## PARKS AND COMMUNITY SERVICES DEPARTMENT

April 12, 2023

### **Subject: The Estates at Cathedral Pines PUDSP (PUDSP2210)**

ESTATES AT CATHEDRAL PINES PUD DEVELOPMENT PLAN PRELIMINARY PLAN

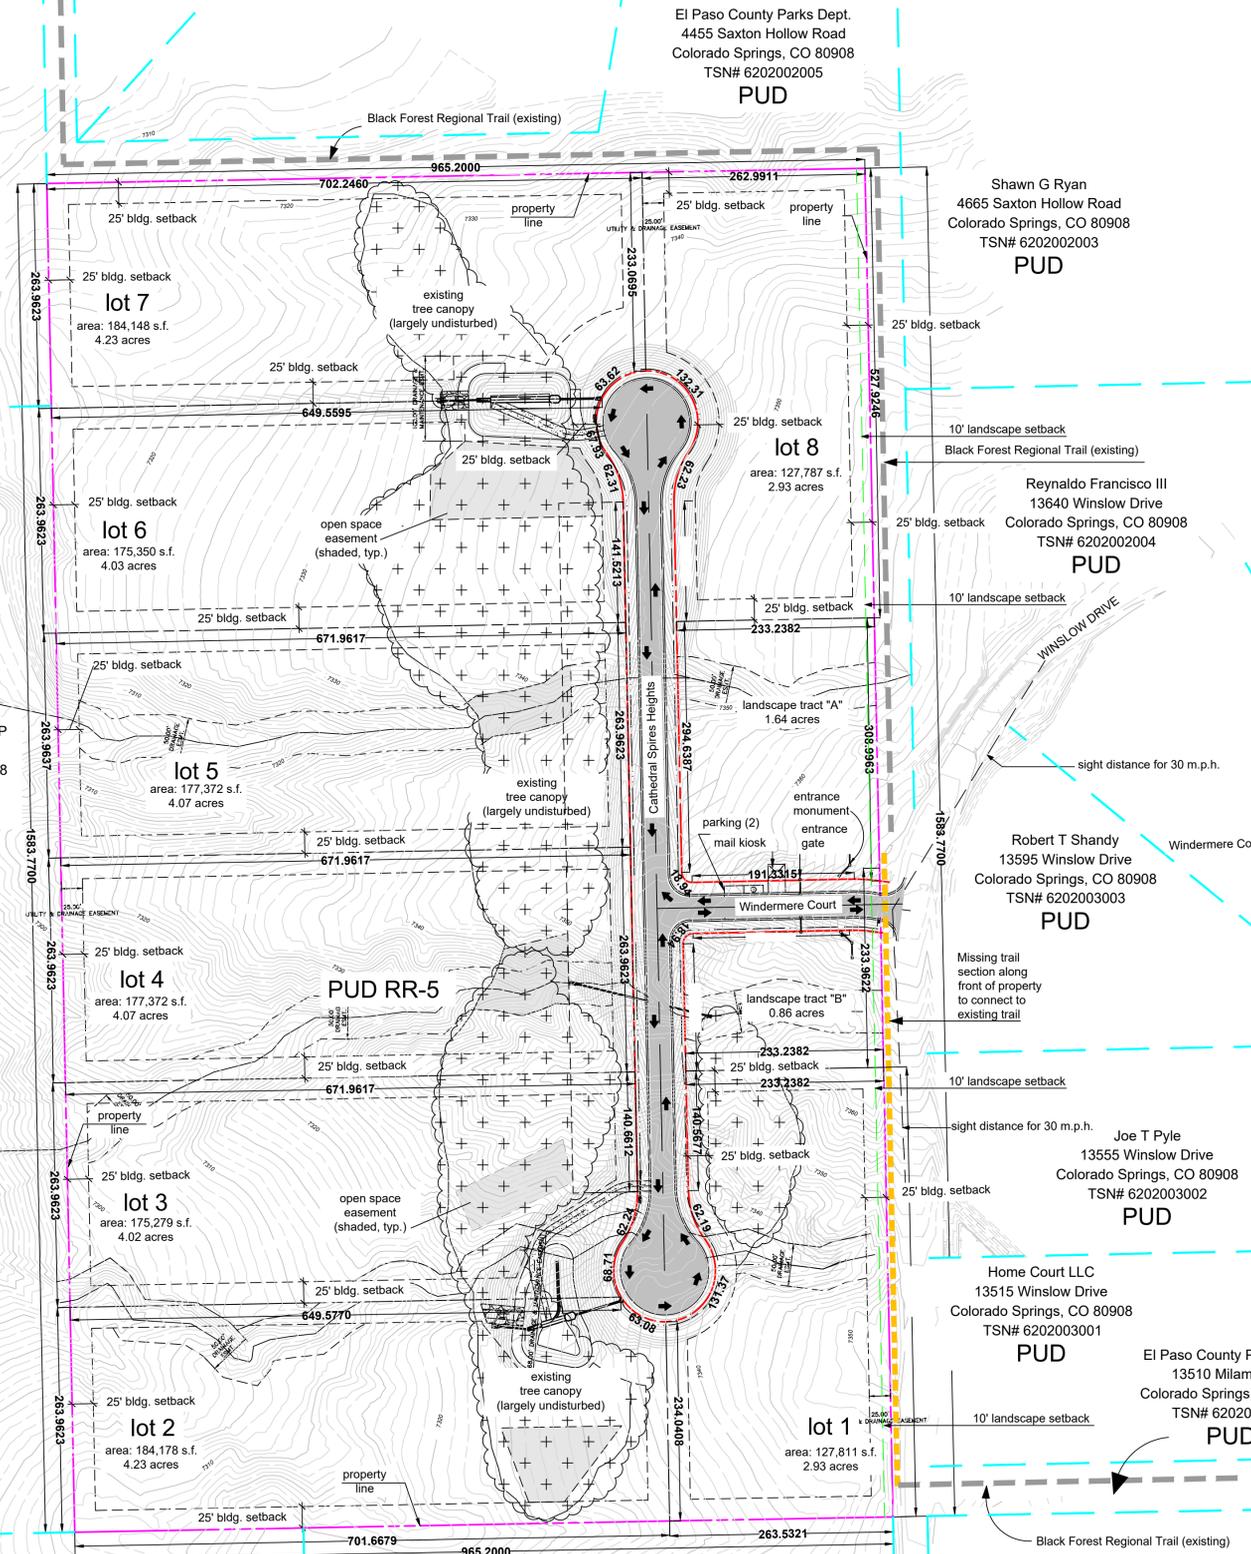
Open space dedications total 2.5 acres (7%) as outlined in the letter of intent, however the PUDSP plans do not clearly identify open space tracts nor is there a land use table to confirm open space dedications. Parks staff would request the applicant show open space tracts and include a land use table on the PUDSP and final plat drawings to confirm the correct dedications are being provided for PUD zoning which is minimum 10% of the total project site area, or 3.051 acres.

along the western and southern property boundary, as well as an internal Black Forest Regional Park trail along Winslow Drive. Consistent with Land Development Code requirements, County Parks seeks trail easements where proposed projects impact county trails. For this application 25-ft wide public trail easements will be sought around the perimeter of the site to allow for the future construction and public use of these trails as outlined below:

1. Designate and provide to El Paso County a 25-foot trail easement, north-south along the eastern boundary of Lot 1 and Lot 8 to connect the existing county trail along Winslow Drive.
2. Designate and provide to El Paso County a 25-foot trail easement, north-south along the western boundary of Lot 6 and 7 for the Palmer Divide Regional Trail.
3. Designate and provide to El Paso County a 25-foot trail easement, east-west along the southern boundary of Lot 1 and Lot 2 for the Palmer Divide Regional Trail.

*The Park Advisory Board recommends that the Planning Commission and the Board of County Commissioners include the following conditions when considering and/or approving The Estates at Cathedral Pines PUDSP: (1) in recognition of the importance of the Black Forest South Candidate Open Space Area, increase open space dedications to minimum 10% consistent with PUD zoning, show them as tracts, and include a land use table on the PUDSP and final plat drawings (2) show on the final plat and dedicate to El Paso County a 25-foot trail easement, north-south along the eastern boundary of Lot 1 and Lot 8 to connect the existing county trail along Winslow Drive; (3) show on the final plat and dedicate to El Paso County a 25-foot trail easement, north-south along the western boundary of Lot 6 and Lot 7 for the Palmer Divide Regional Trail; (4) show on the final plat and dedicate to El Paso County a 25-foot trail easement, east-west along the southern boundary of Lot 1 and Lot 2 for the Palmer Divide Regional Trail; (5) the trail easements shall be shown on the final plat and allow for public access, as well as construction and maintenance by El Paso County; (3) require fees in lieu of land dedication for regional park purposes in the amount of \$3,680 will be due at recording of the forthcoming final plat(s).*
